Our ref: DOC21/26870
Senders ref: SSD 10425

Response to Submissions – Tallawong Station Precinct South – Stage 2 Detailed Design Modification Application 1 (SSD 10425)

FIGURE D1 FLOOD LEVEL DIFFERENCE – 20% AEP

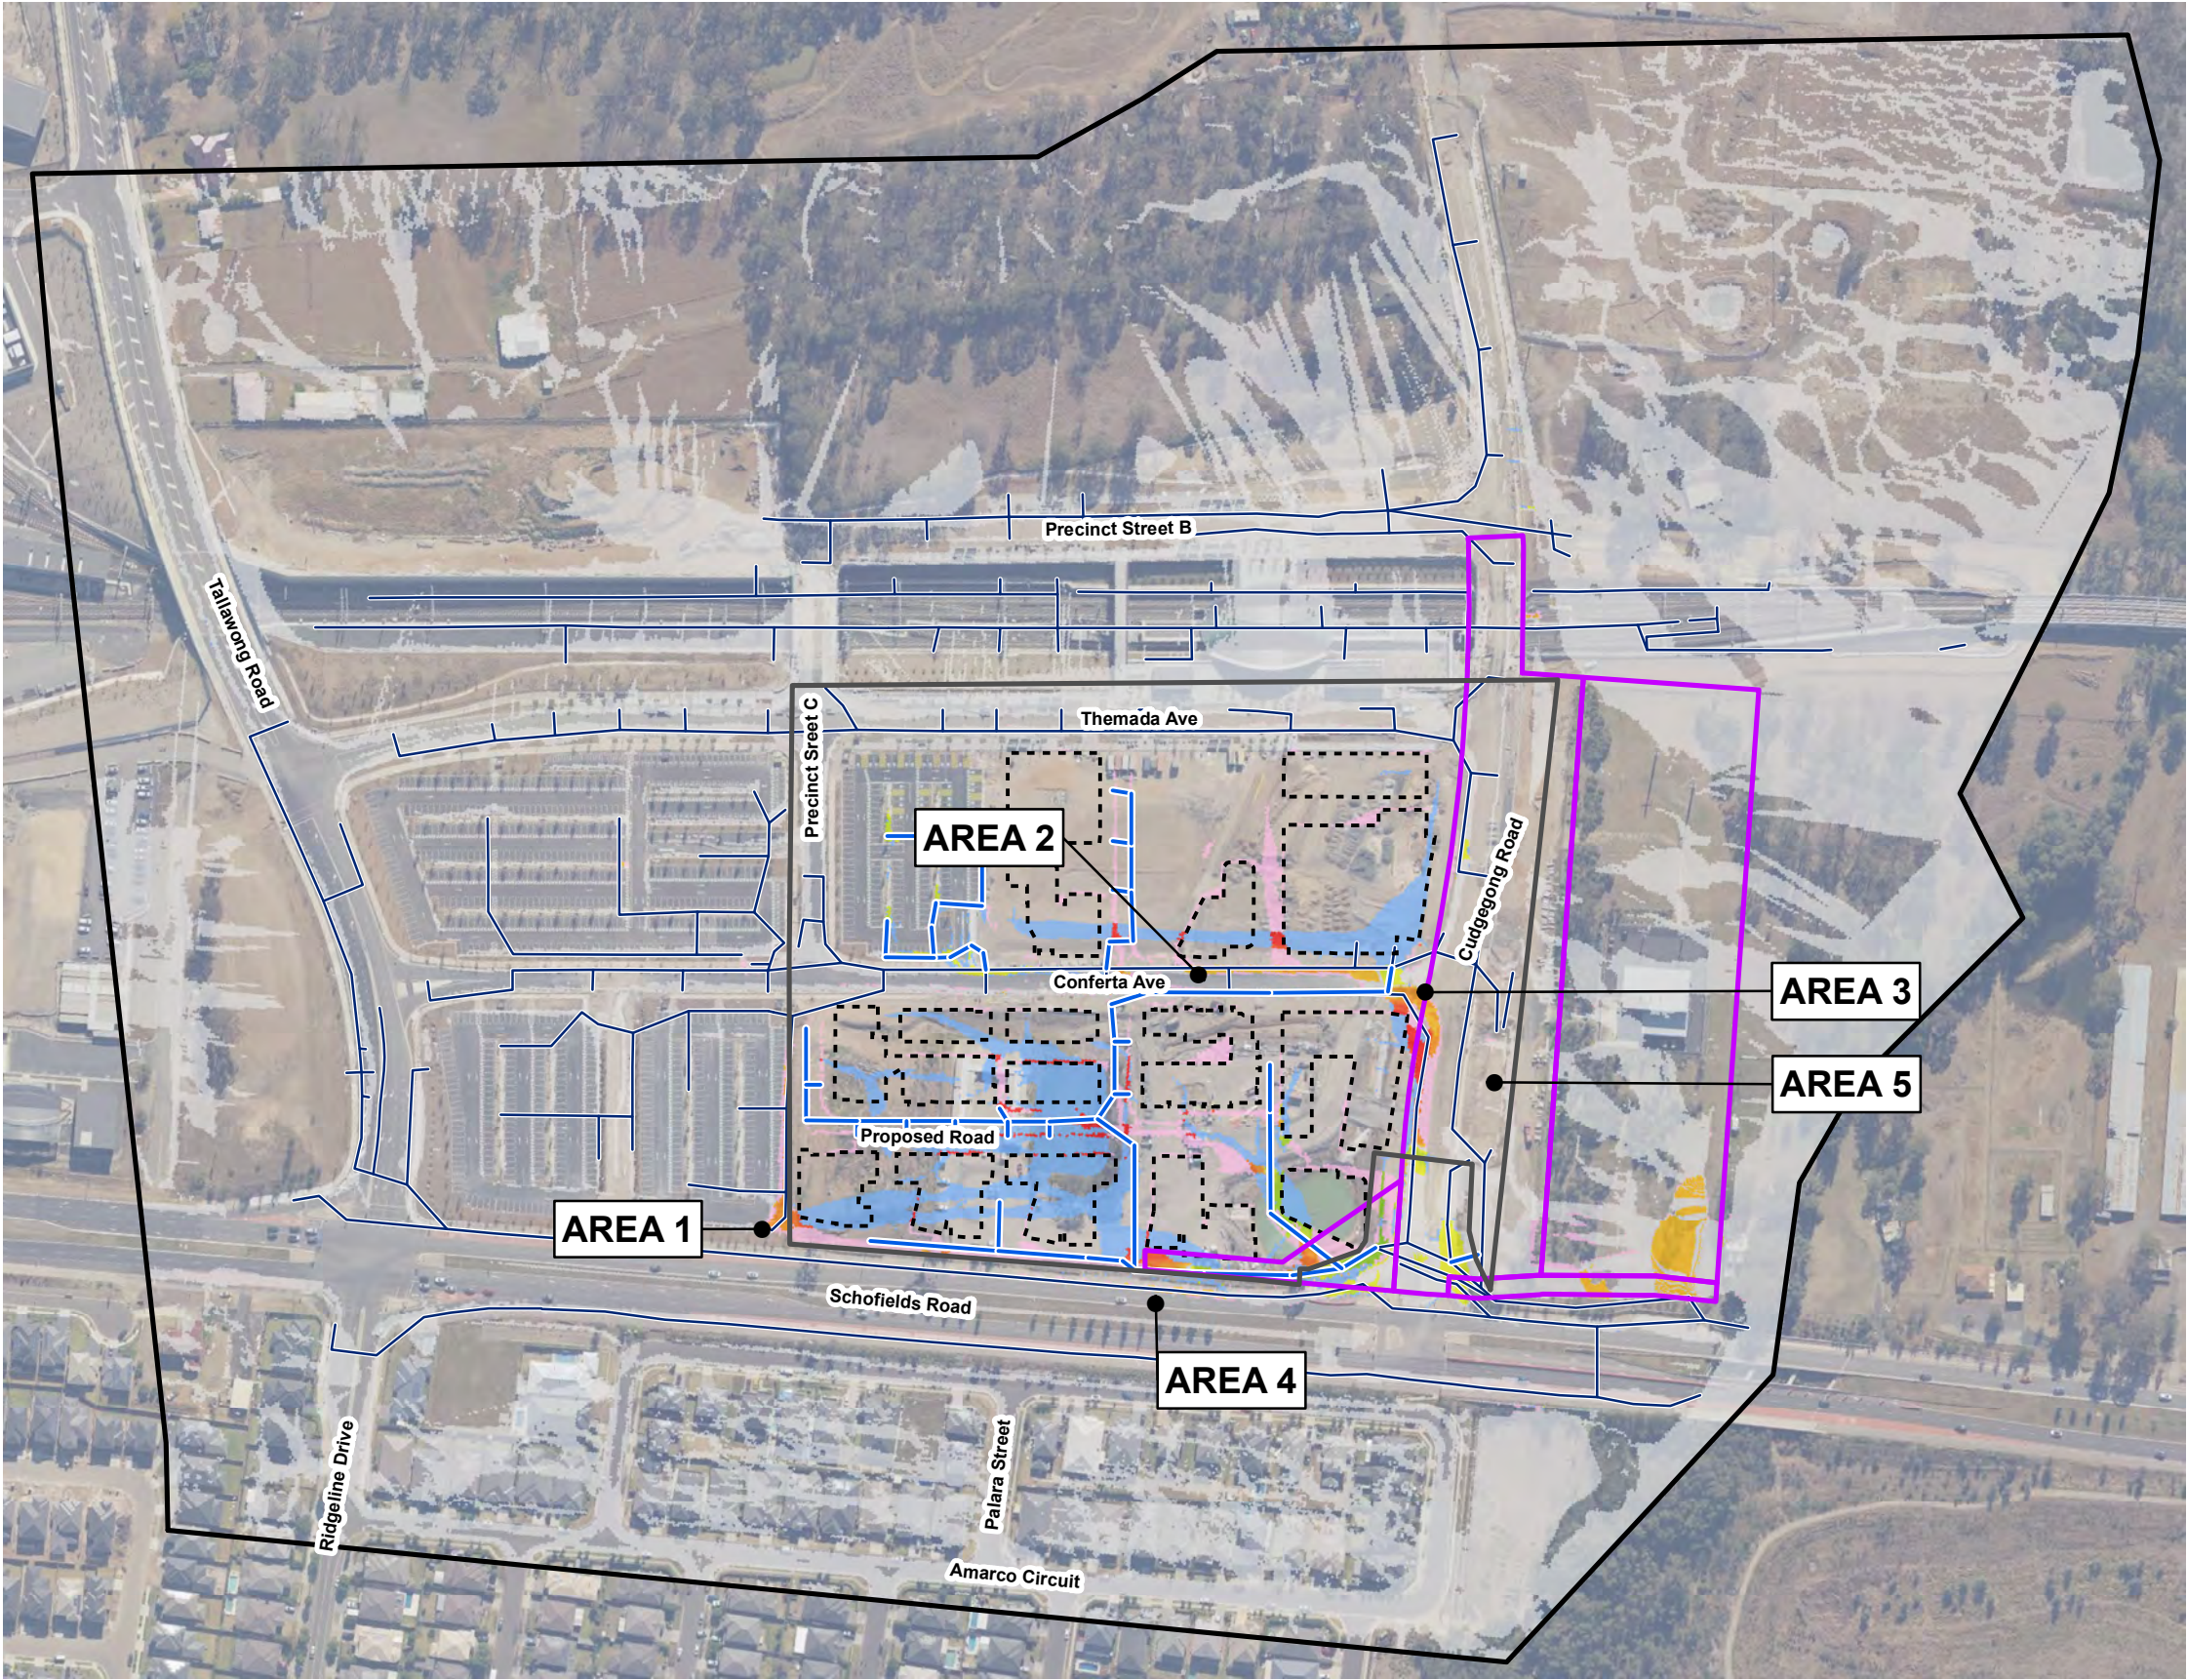
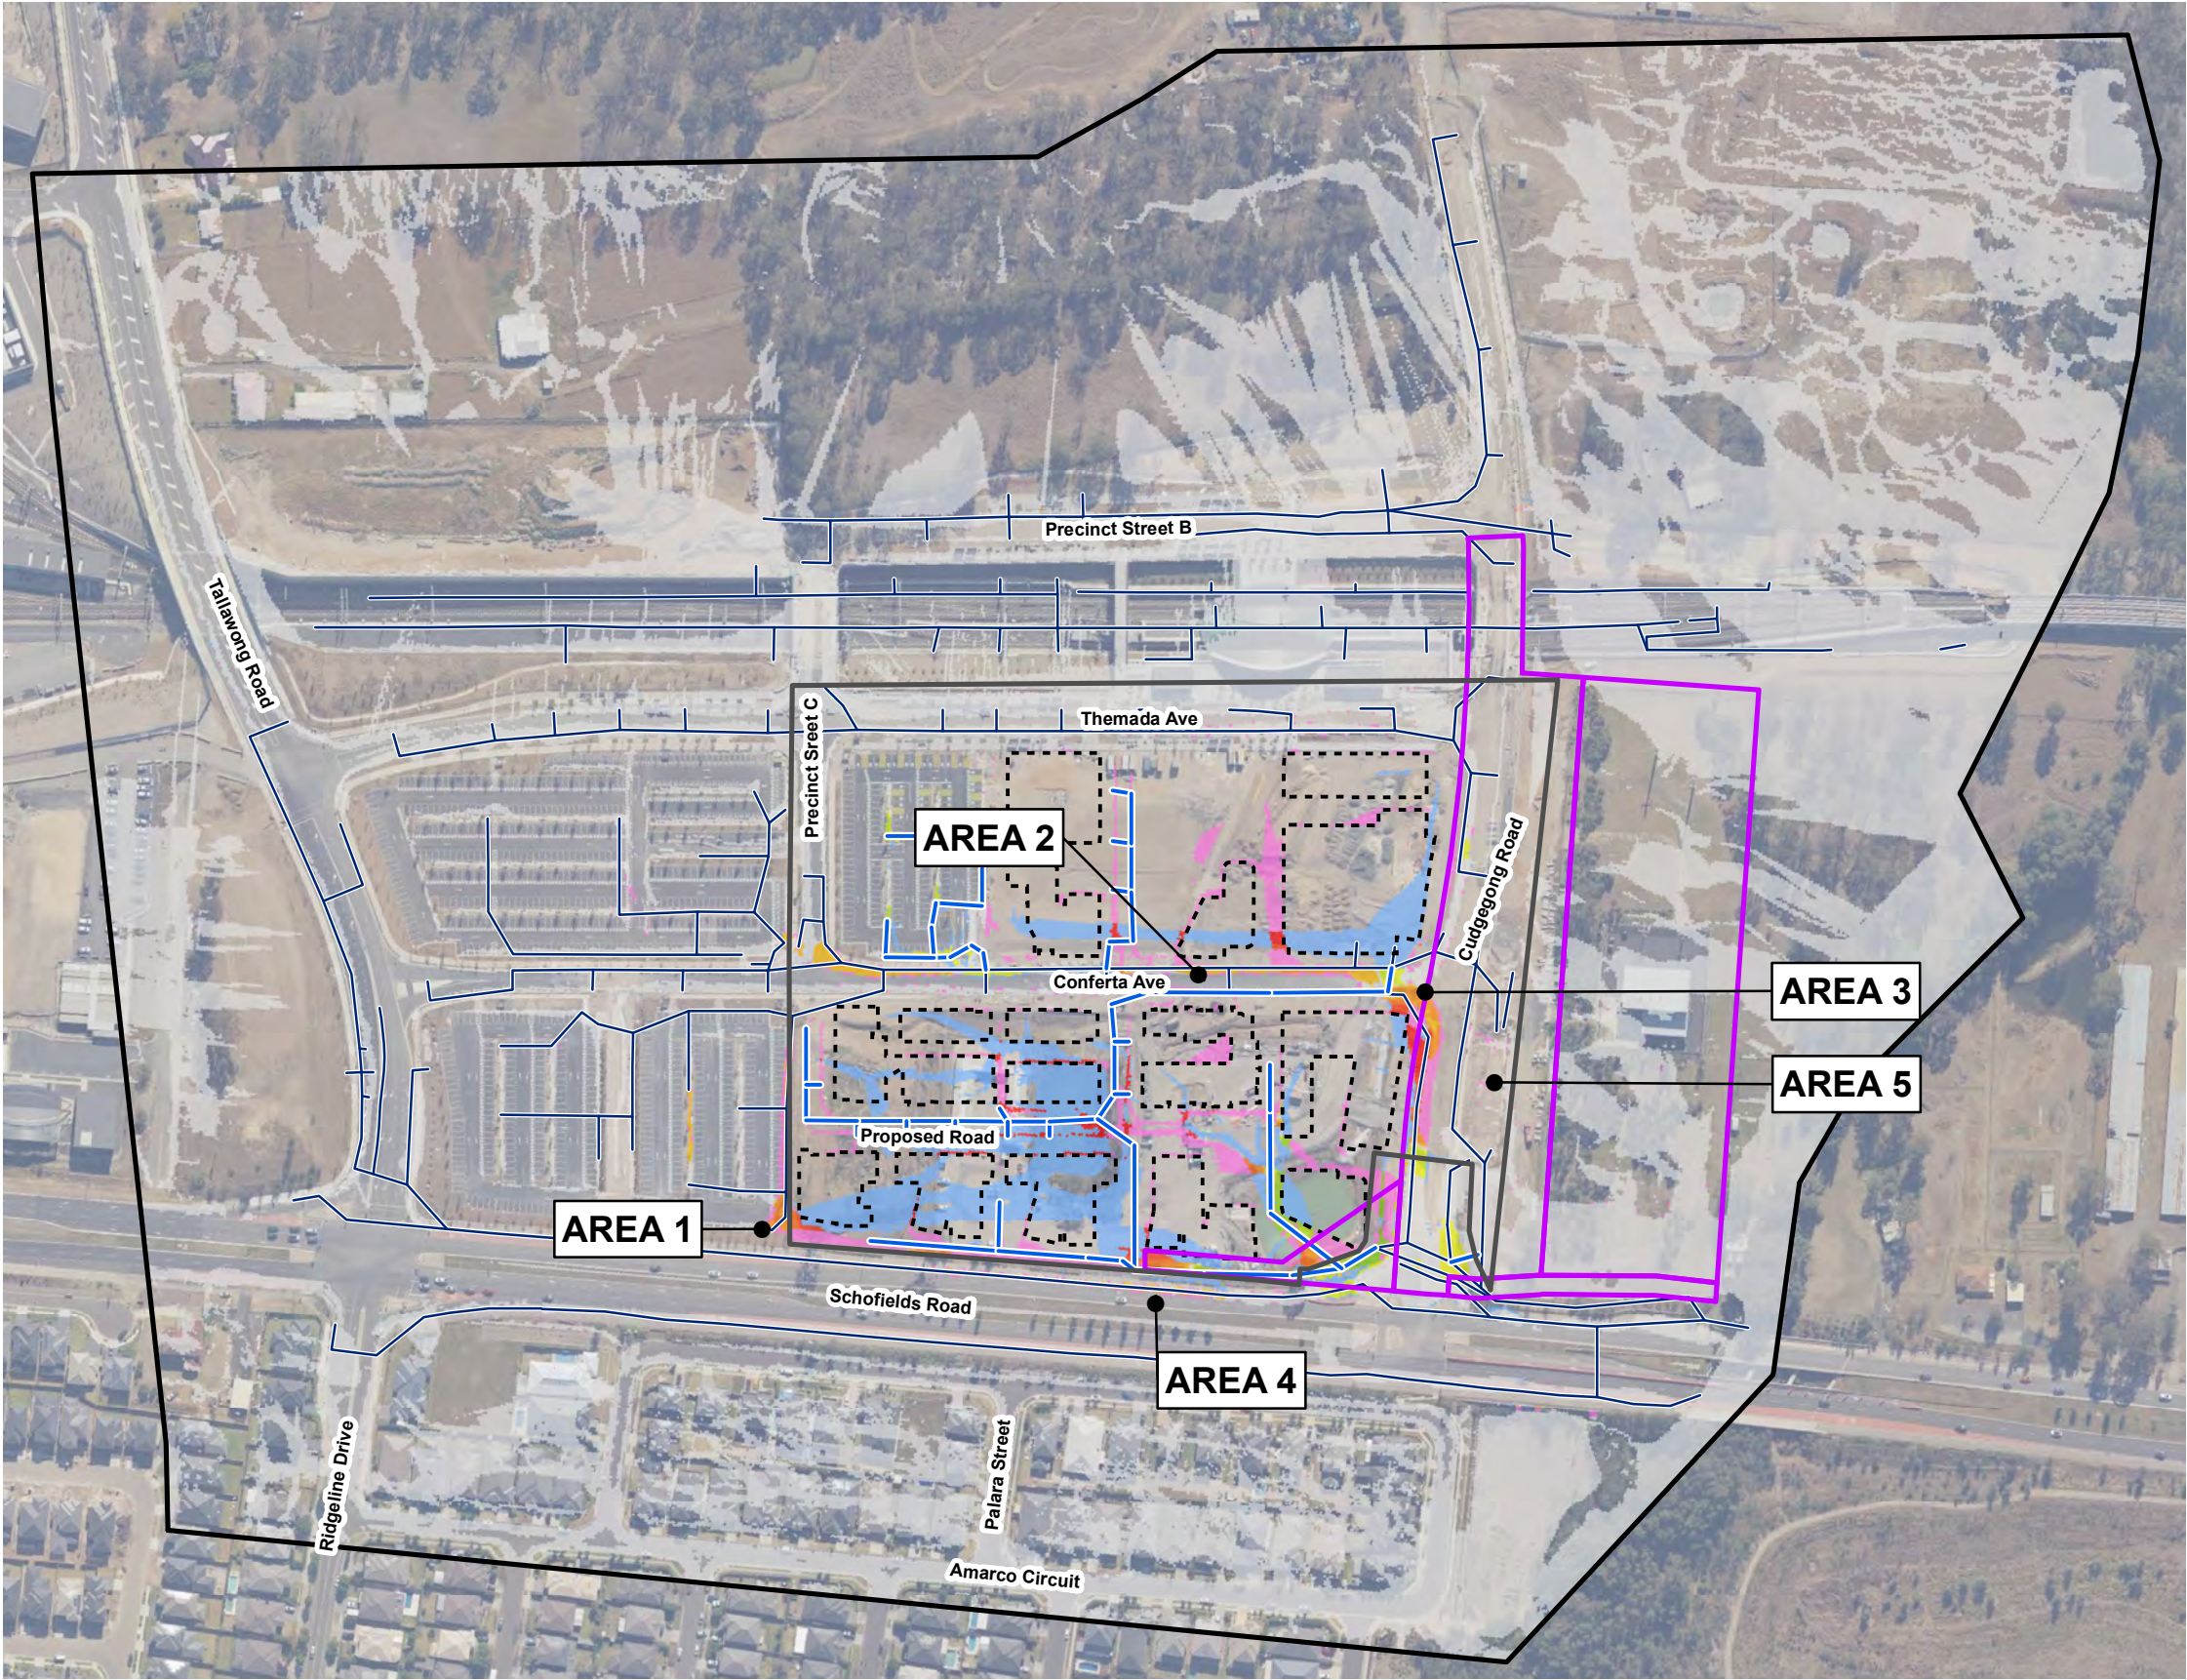
- The flood level difference maps need careful review as they show some discrepancies particularly at the southern corner of Cudgegong Road. The difference maps show reduction instead of increase in levels at this area for all flood events.
